Re: Sawmill Tract J
800 20TH St. NW
Traffic Circulation Layout
 Engineer's Stamp 02-28-23 (J13-D076B)

Based upon the information provided in your submittal received 03-24-23, the above referenced plan cannot be approved for Building Permit until the following comments are addressed:

RONALD R. BOHANNAN P.E. #7868	800 20TH ST ALBUQUERQUE, NM	DRAWN BY SB
	CONCEPTUAL TRAFFIC CIRCULATION LAYOUT	DATE 03-15-23
	TIERRA WEST, LLC 5571 MIDWAY PARK PL NE ALBUQUERQUE, NEW MEXICO 87109 (505) 858-3100 www.tierrawestllc.com	DRAWING
		SHEET # TCL-1
		JOB # 2022136

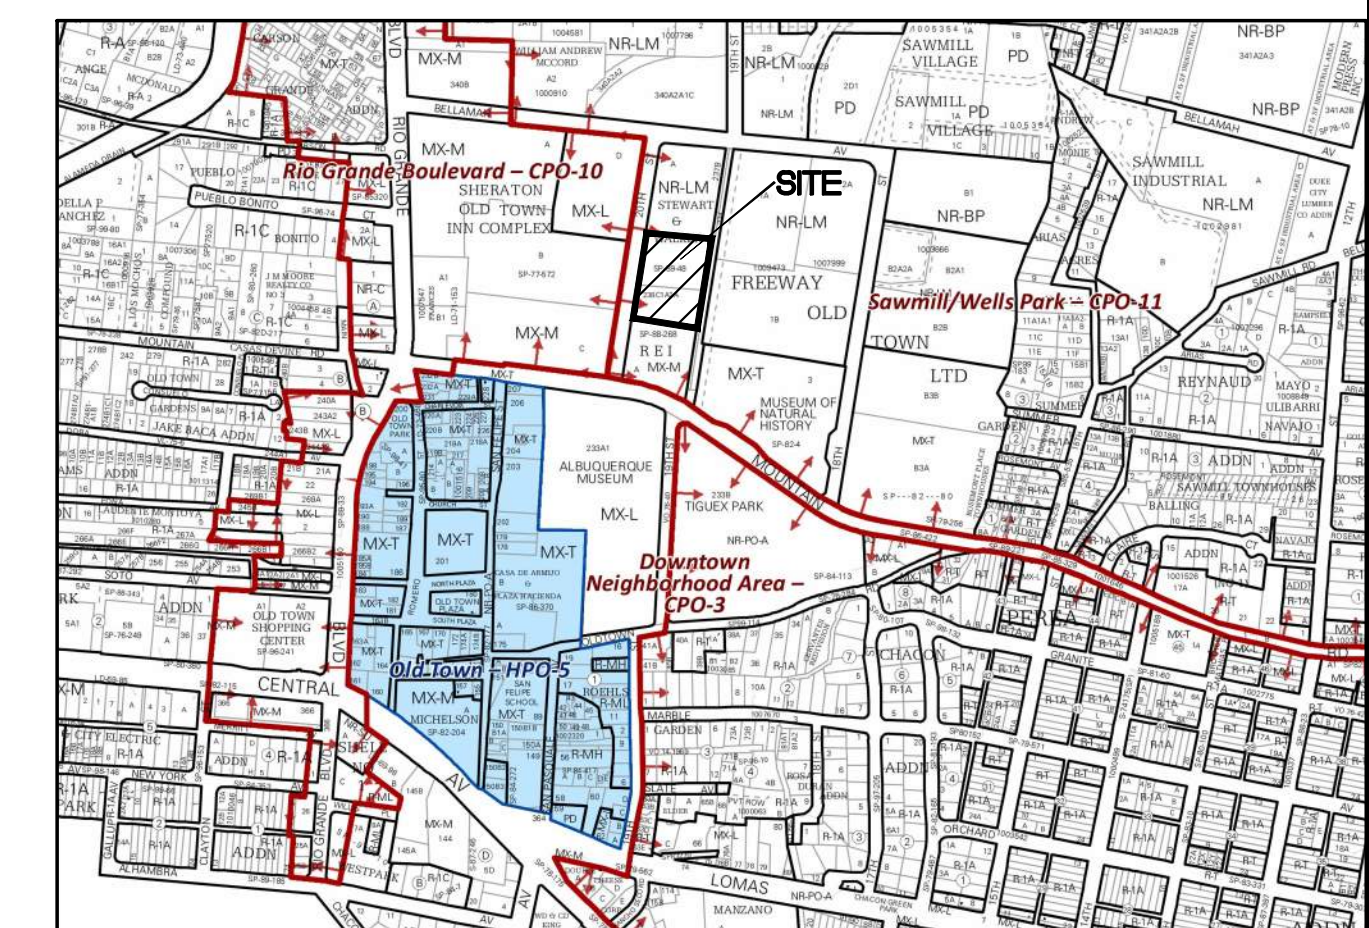
1. Identify all existing access easements and rights of way width dimensions.
2. Is there any basement or second floor parking spaces? If so, please provide a site plan showing all the proposed parking spaces, details and dimensions.
3. The site access's east leg appears to encroach with the adjacent property. Please provide the adjoining property owner agreement.

5. Please provide all proposed drive aisles width.

6. Please provide ADA aisle for all the proposed ADA parking spaces.

7. The ADA accessible spaces must include an access aisle. Van accessible aisles should be 8ft wide; all others should be 5ft wide.
8. The ADA access aisles shall have the words **"NO PARKING"** in capital letters, each of which shall be at least one foot high and at least two inches wide, placed at the rear of the parking space so as to be close to where an adjacent vehicle's rear tire would be placed. (66-1-4.1. B NMSA 1978)
9. ADA curb ramps must be updated to current standards and have truncated domes installed.
10. Please show on the site plan the location the proposed Motorcycle parking spaces.
11. The pavement marking "MC" should be shown in the opposite direction for motorcycles entering the parking space.
12. A 5 ft. keyway is required for dead-end parking aisles. Please show this dimension on

the site plan.

13. Per the IDO, a 6 ft. wide ADA accessible pedestrian pathway is required from the public sidewalk to the building entrances. Please clearly show this pathway and provide details.

14. Per DPM, a 6 ft. wide ADA accessible pedestrian pathway is required from **EACH** ADA parking stall access aisles to the building entrances. Please clearly show this pathway and provide details.

15. Define ADA pathway by labeling ramps or flush pavement.
16. ADA accessible pedestrian pathway should not be placed behind parking space or adjacent to a vehicular way. Vehicle and pedestrian/wheel chair conflicts should be avoided as much as possible.

17. Curbing should be installed to delineate landscape, parking, and pedestrian ways and identify points of access. Please call out detail and location of barrier curb.

18. Refuse vehicle maneuvering shall be contained on-site. The refuse vehicle shall not back into the public right of way.; provide a copy of refuse approval.

20. It is not apparent what type of pavement surface is being proposed. A hard driving surface will be required as part of this proposed project for parking area and drive aisles.

21. Please specify the City Standard Drawing Number when applicable.
22. Add a note stating "All broken or cracked sidewalk must be replaced with sidewalk and curb & gutter." A build note must be provided referring to the appropriate City Standard drawing.
